Temperature Controlled Warehouse Facility Modification 1 (SSD-8586218-Mod-1)
Request for Additional Information

I refer to the recent lodgement of the modification application for the Temperature Controlled Warehouse Facility (SSD-8586218-Mod-1). After careful consideration, the Department is requesting that you provide additional information.

TITLE				
MEZZ FLOOR PLAN & SECTION				
DATE	SCALE	PROJECT NO.	DWG NO.	REVISION
23/02/2021	As indicated @ A1	20245	DA230	B

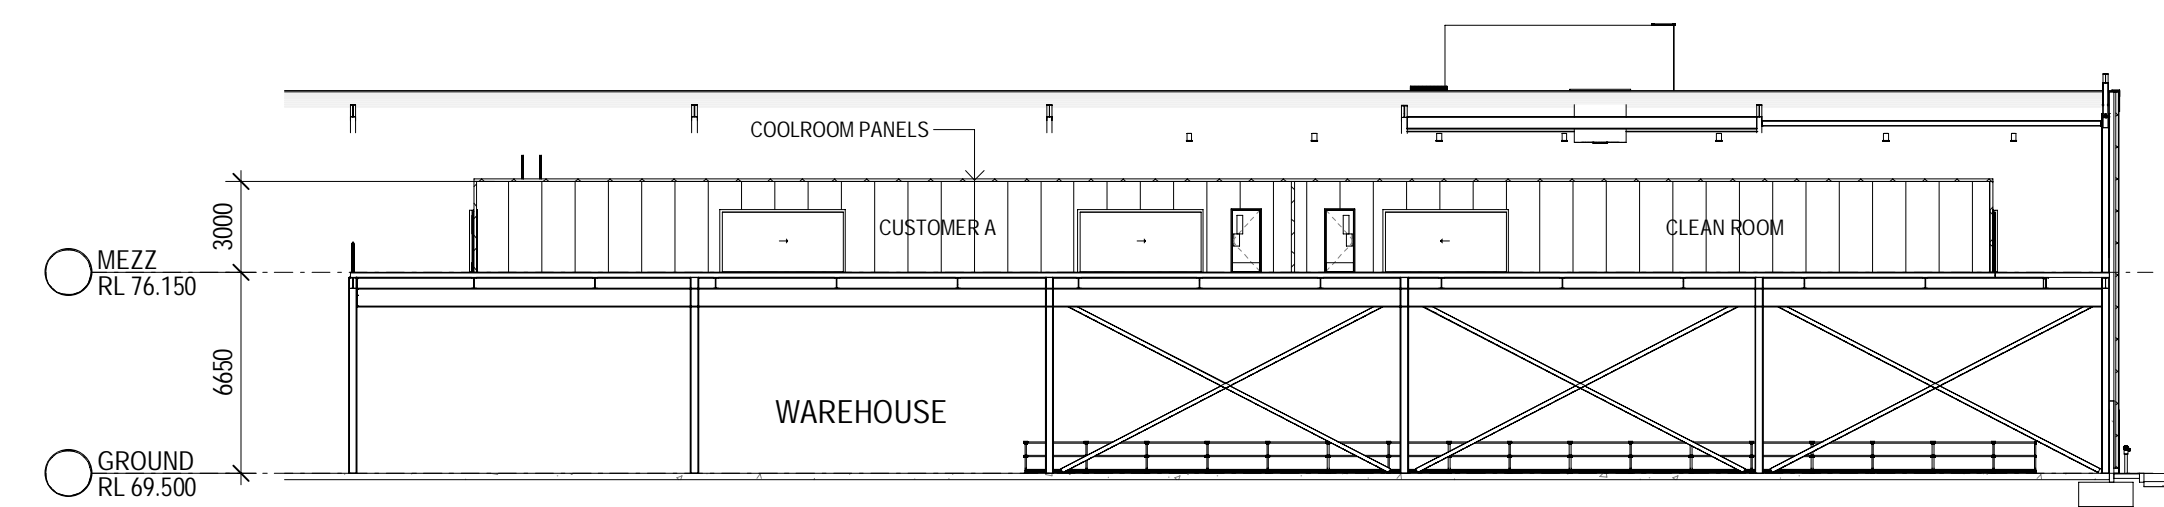
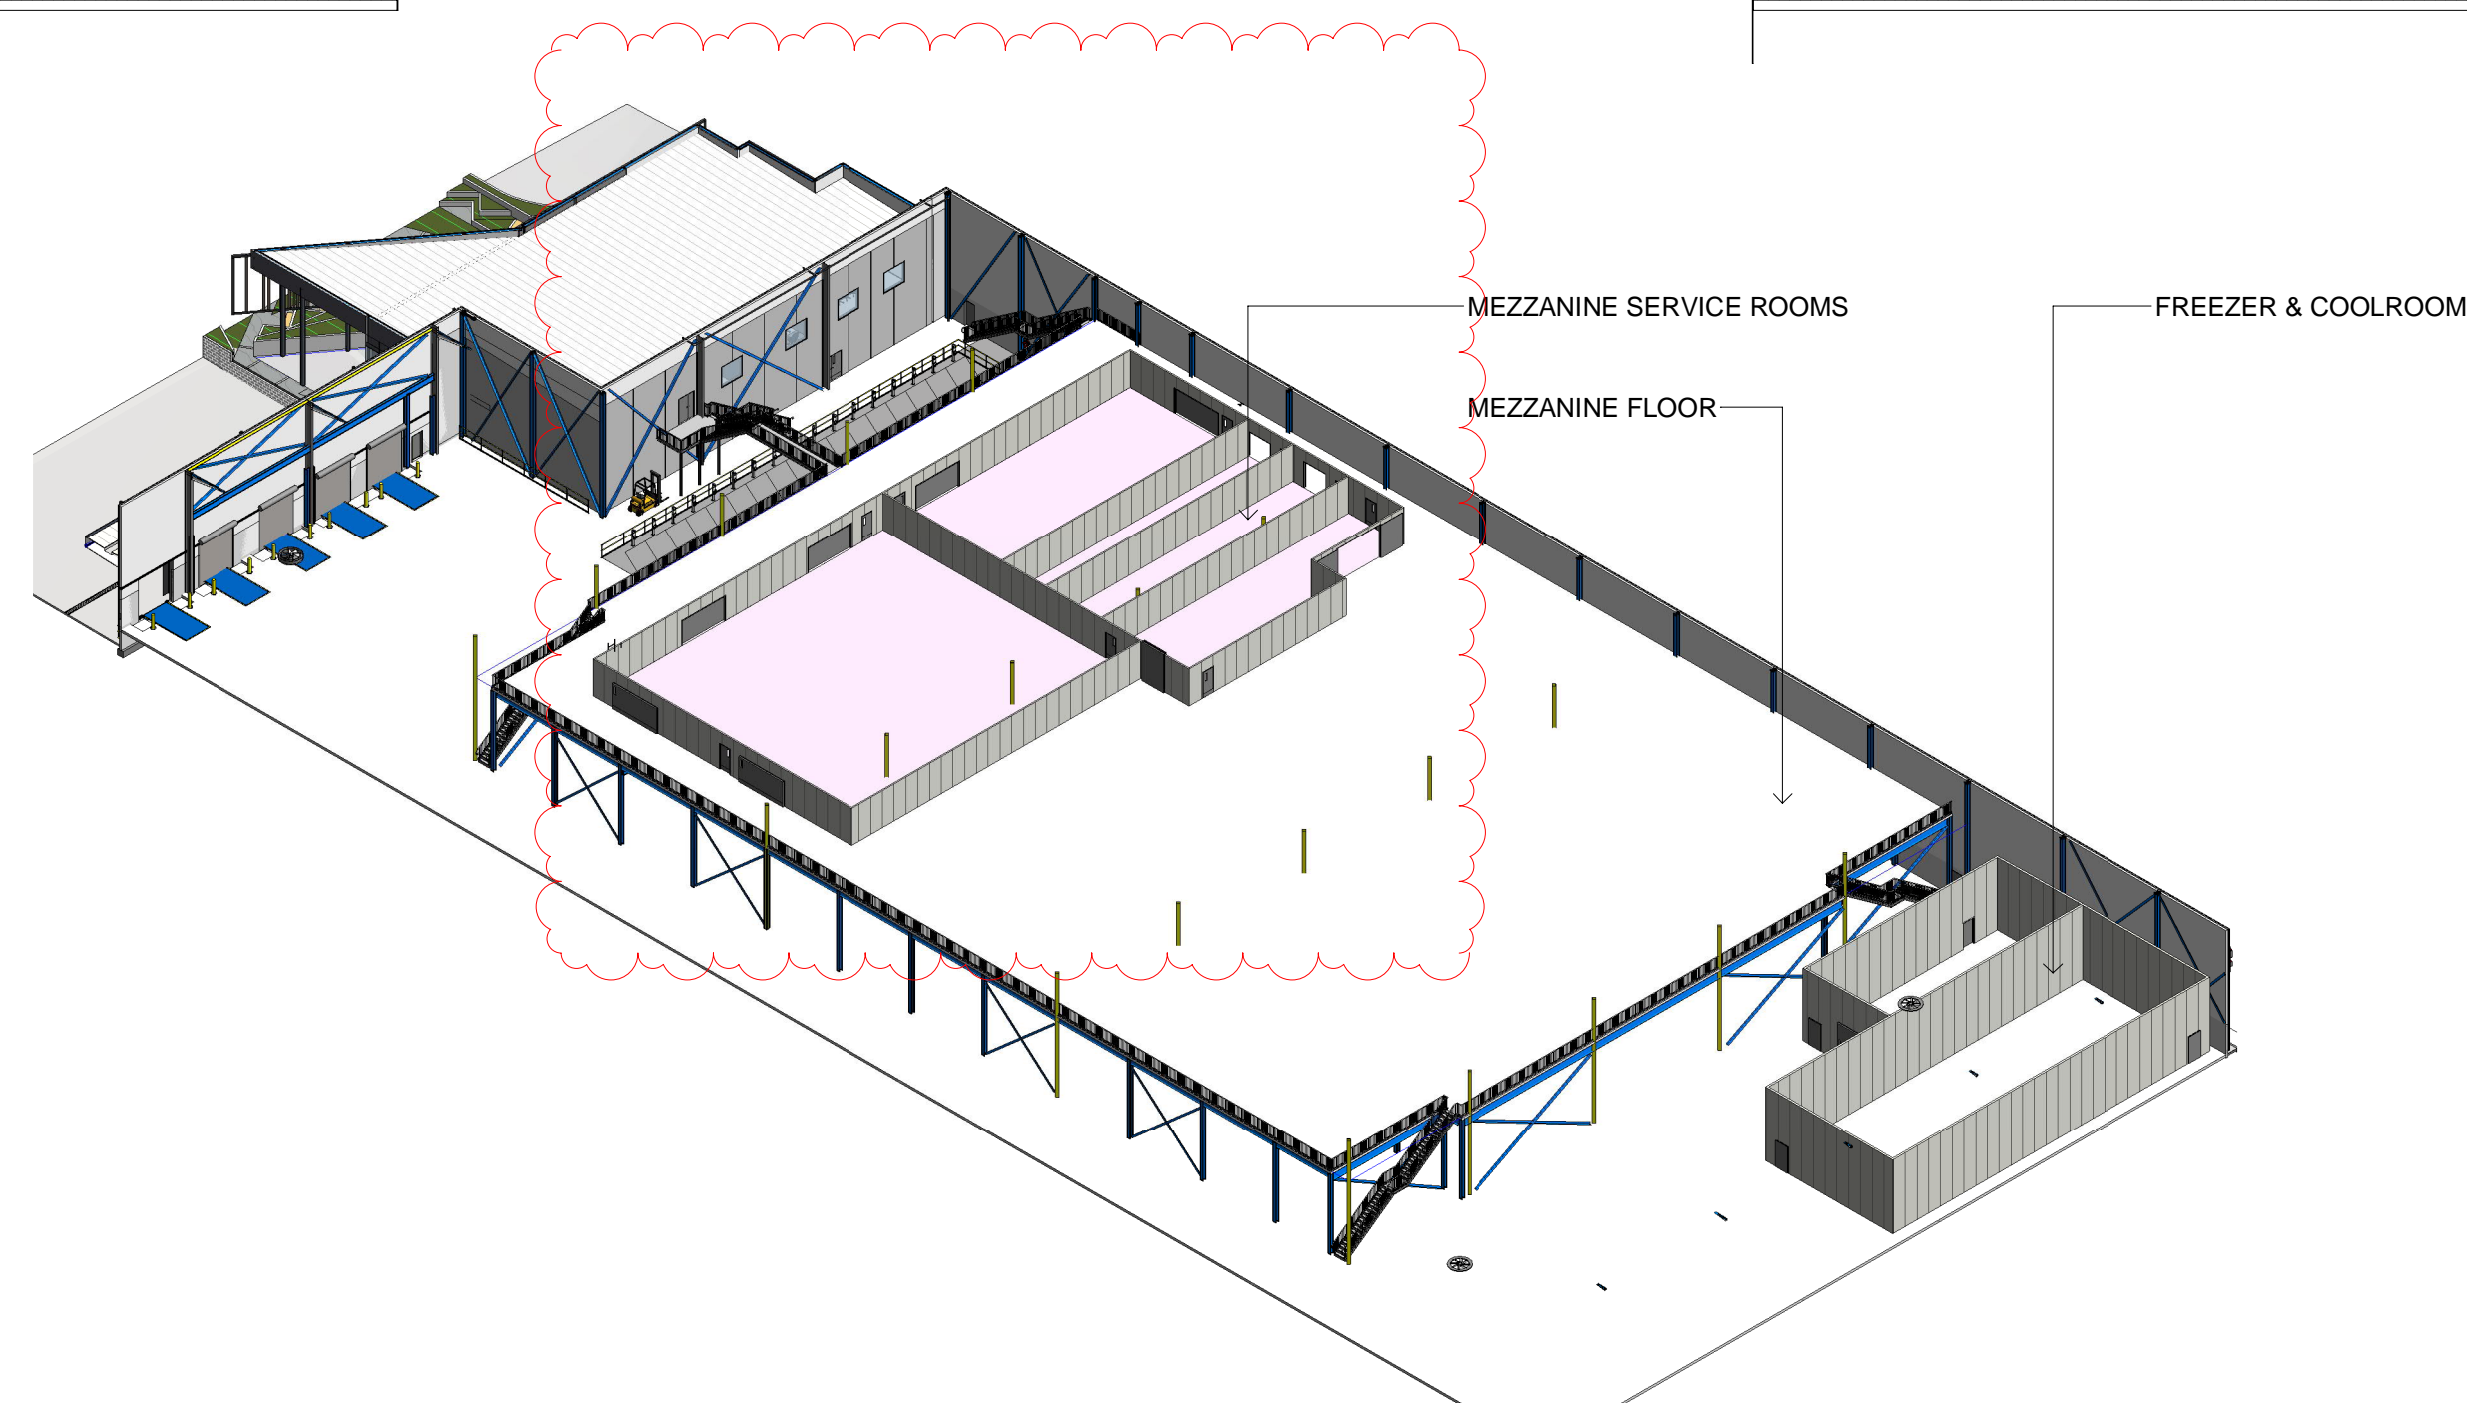
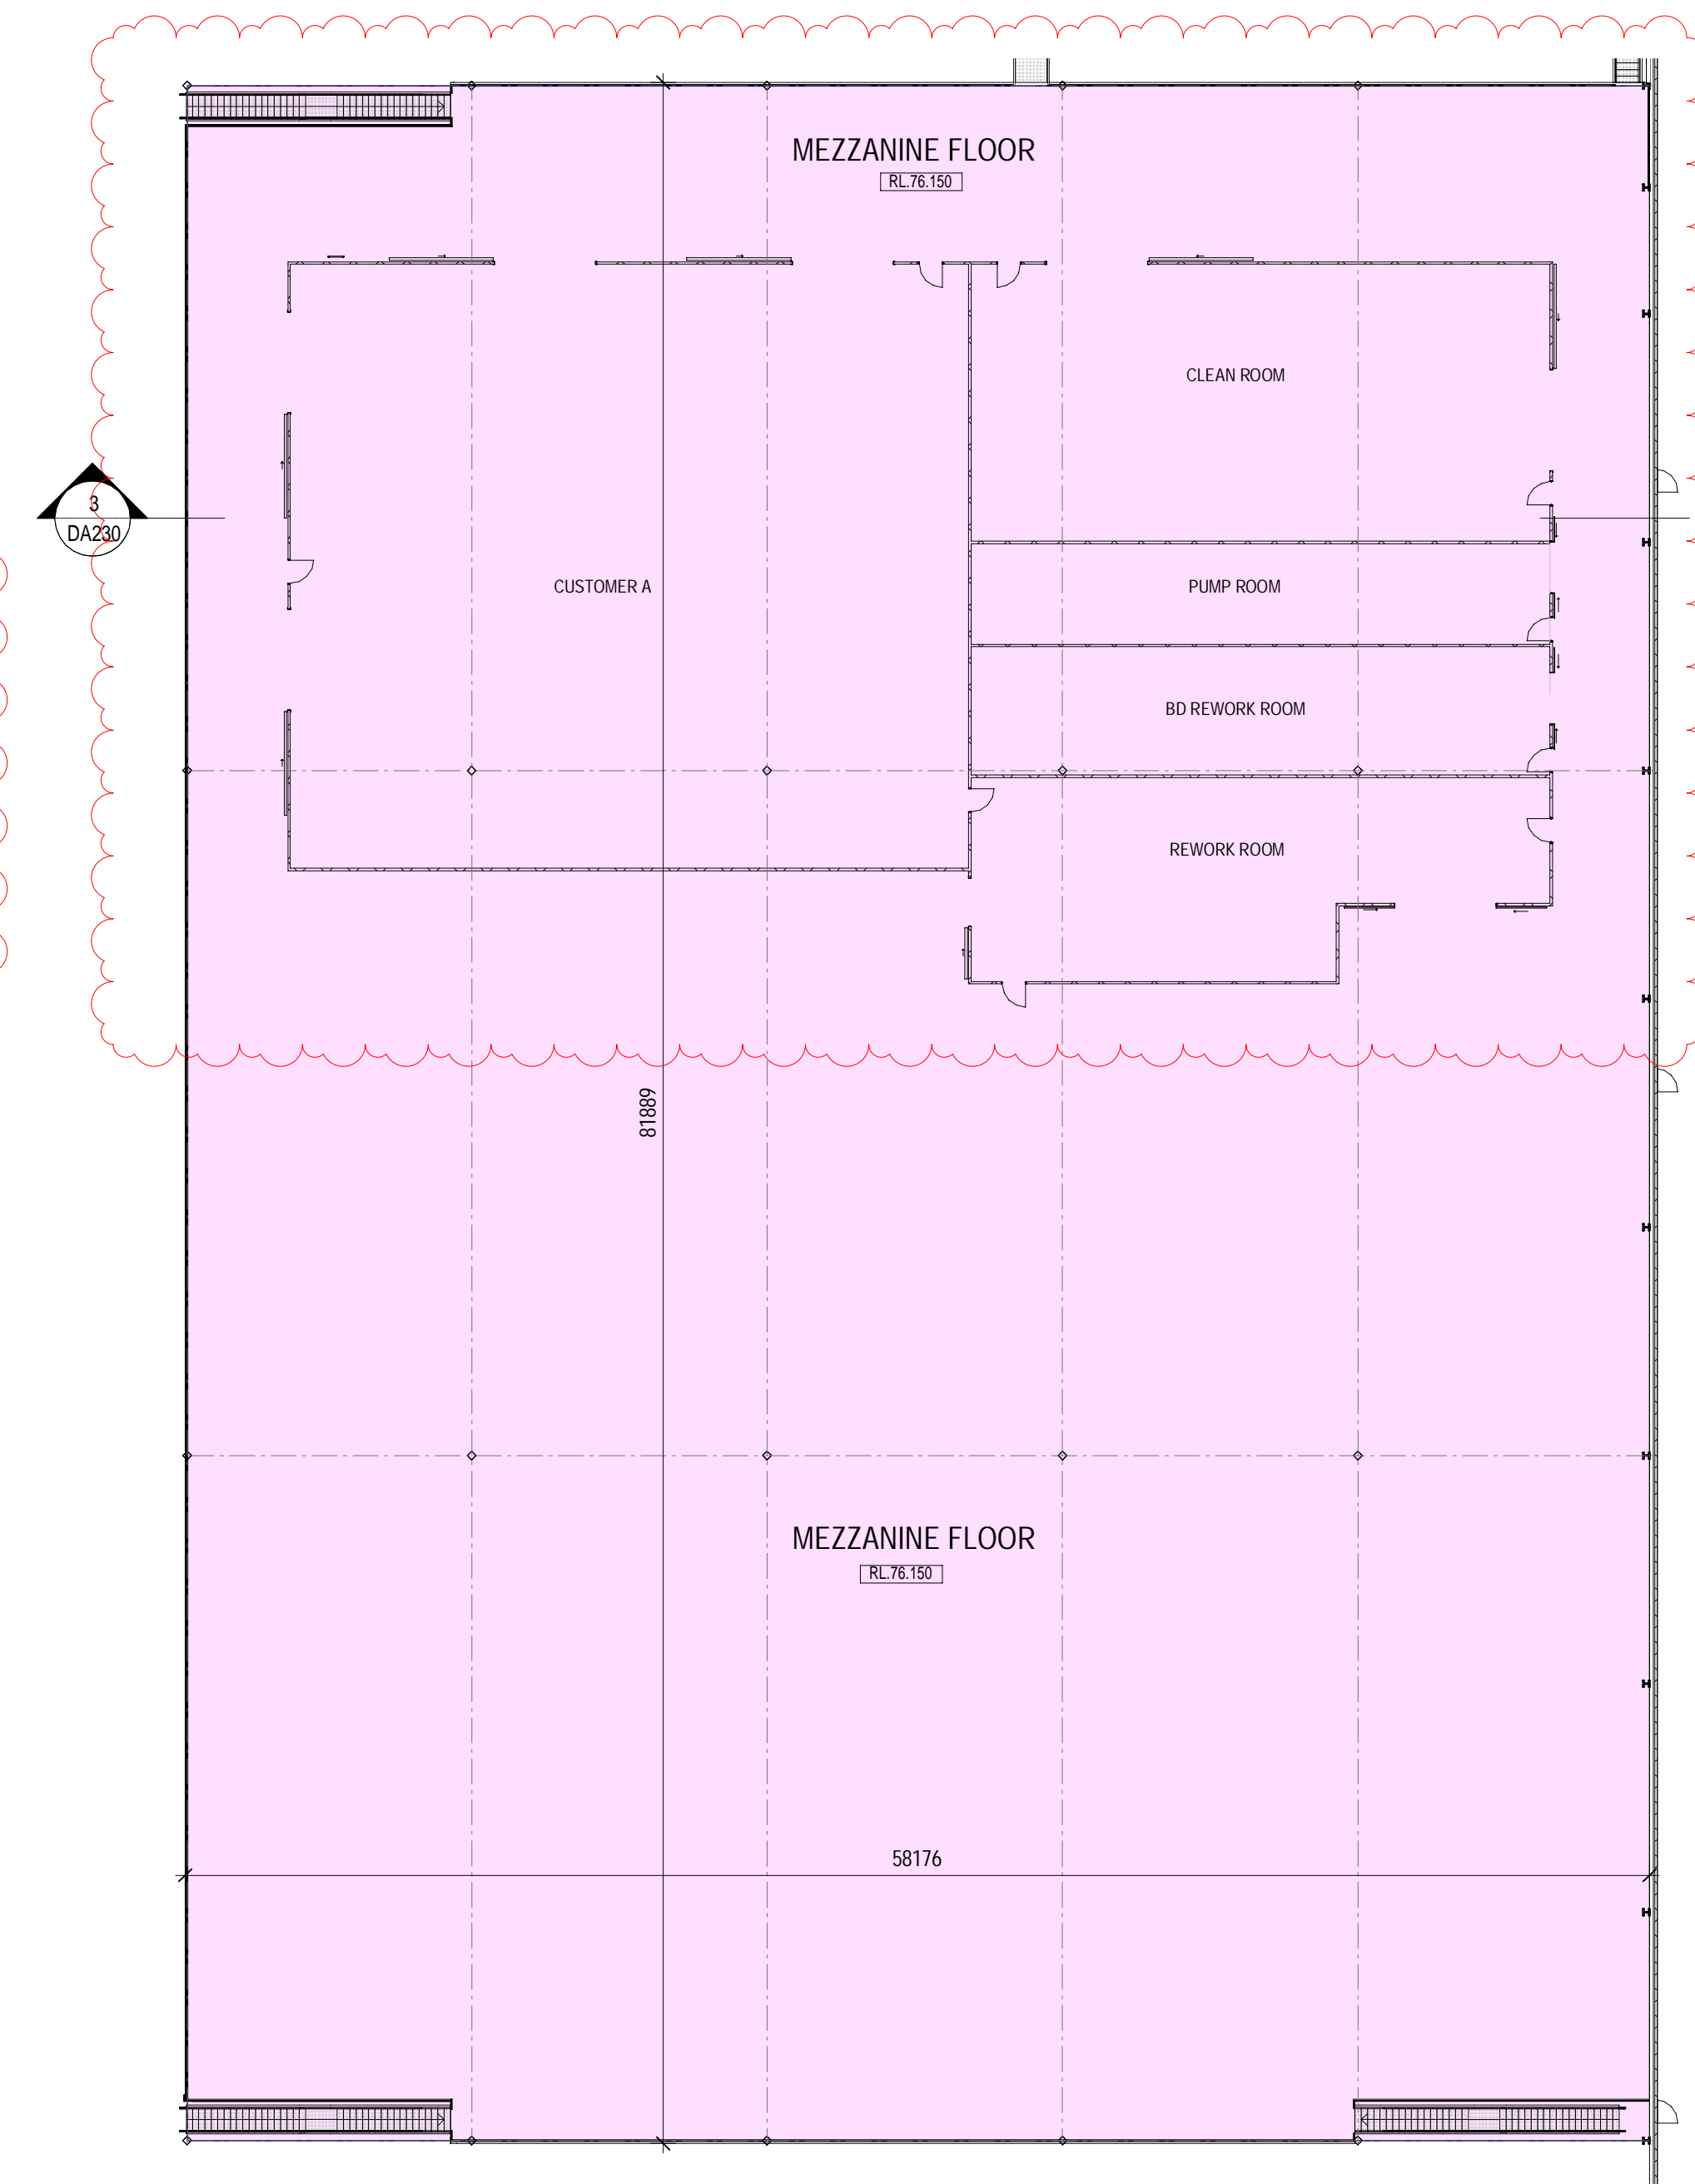
1. Section 2.1.1 of the supplied report notes that several rooms on the mezzanine floor will be used to process, service and repair goods, which may be considered an industrial activity. The Department considers the information provided in the modification application report to be insufficient to understand the exact activities proposed and how this aligns with the use of the development, as consented to. Further details on this aspect of the modification must be provided, including:

- (i) the exact processes and activities that are proposed to be carried out, including good's entry and exit from the facility and their relation to the use of the site as a warehouse. Details should also be provided on any additional impacts these processes may have, including waste or additional staffing levels

- (ii) further justification as to how the additional industrial activities can be considered as substantially the same development to the existing consent for a warehouse facility.
